File No: R/2015/8/B
Our Ref: 2015/579484

RE: Barangaroo South – Crown Sydney Hotel Resort (SSD 6957)
City of Sydney response to Applicant's Response to Submissions

I write in relation to the Department's letter dated 22 October 2015 inviting the City to review Crown Sydney Property Pty Ltd's Response to Submissions (RtS) for the proposed State Significant Development Application (SSD DA) for Crown Sydney Hotel and Resort in Barangaroo South.

Figure 2: Applicant supplied image of the Foreshore Promenade

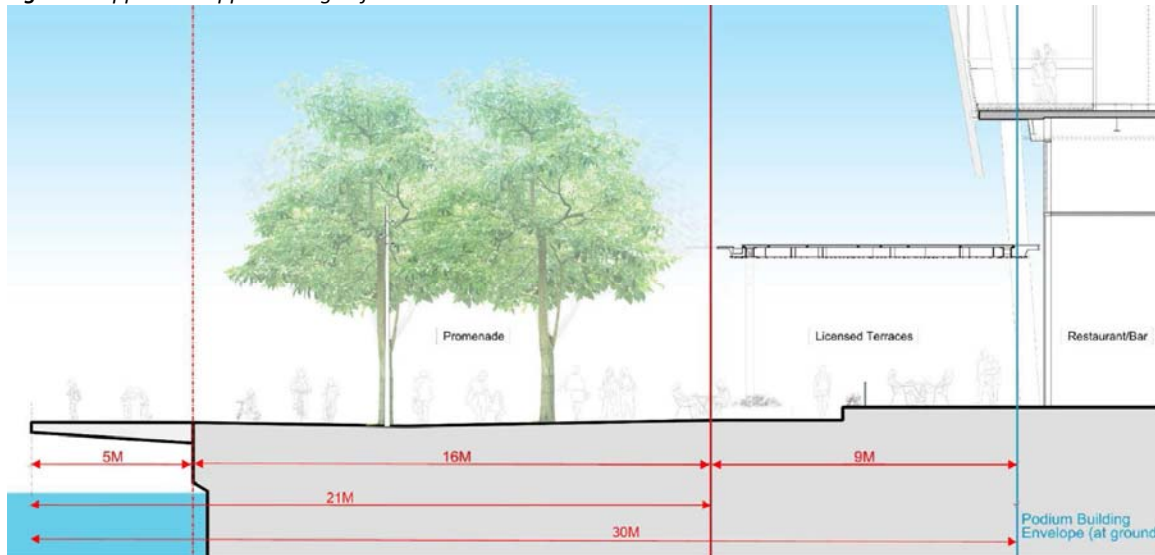
- (a) Reduction in the width and public amenity quality of the waterfront promenade through transgression of the continuous parkland frontage;
- (b) Northern extent of the podium protrudes into a view corridor along Gas Lane to and from Hickson Road to the harbour. The podium should be rationalised;

Figure 4: Elevation depiction of proposed signage

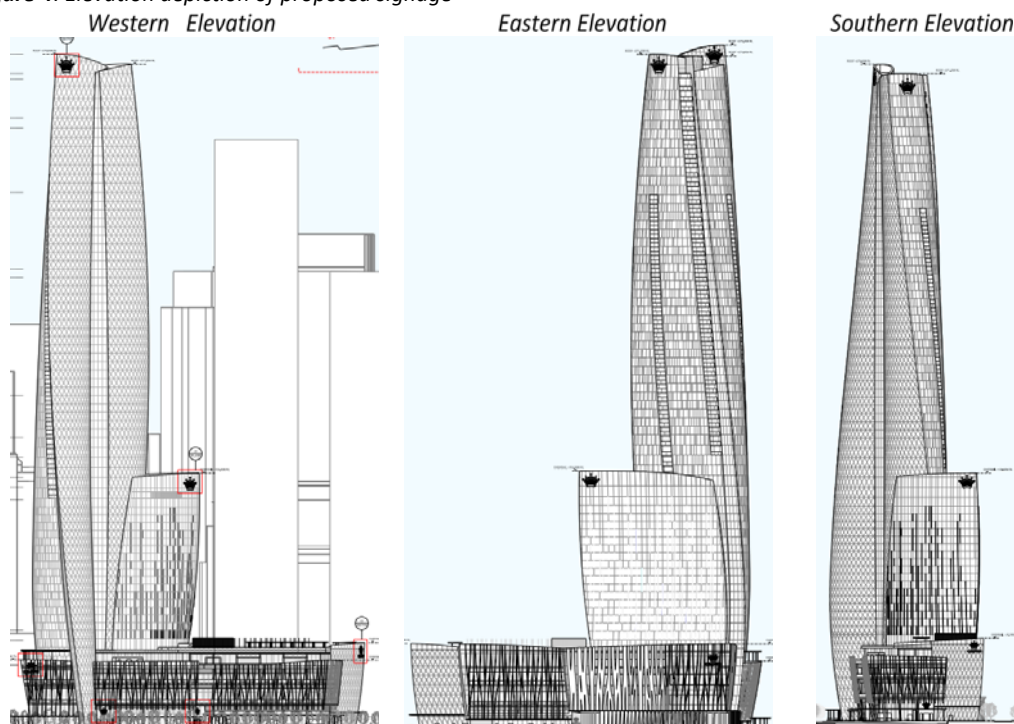
- (f) Signage and branding on the podium and tower should be integrated with the quality and form of the building. Building identification signage is excessive as signage is placed around every pedestrian entry to the building when visitors will already have had exposure to other signage prior to that point; and

Figure 5: Wind Mitigation Measures including trees, glass blades, canopies and deployable shades

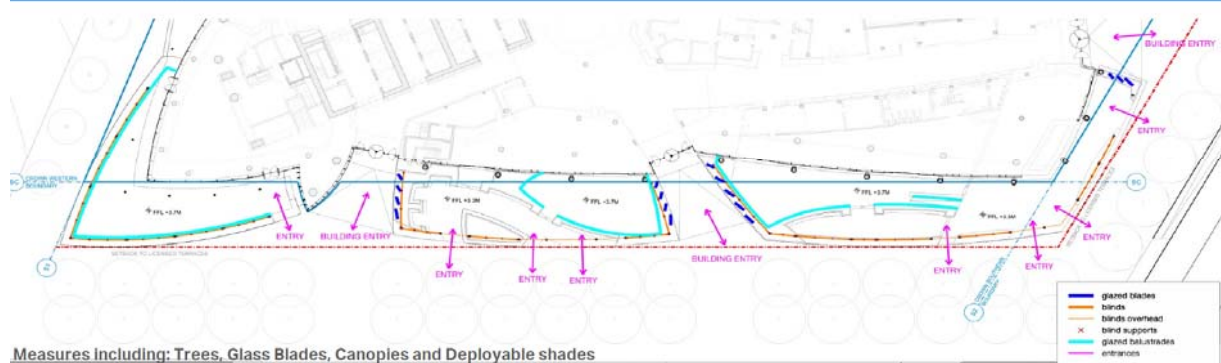
- (e) Ineffective wind mitigation has been designed into the base of the tower at its northern end to reduce reliance upon enclosing structures and landscaping at the ground level along the harbour waterfront;
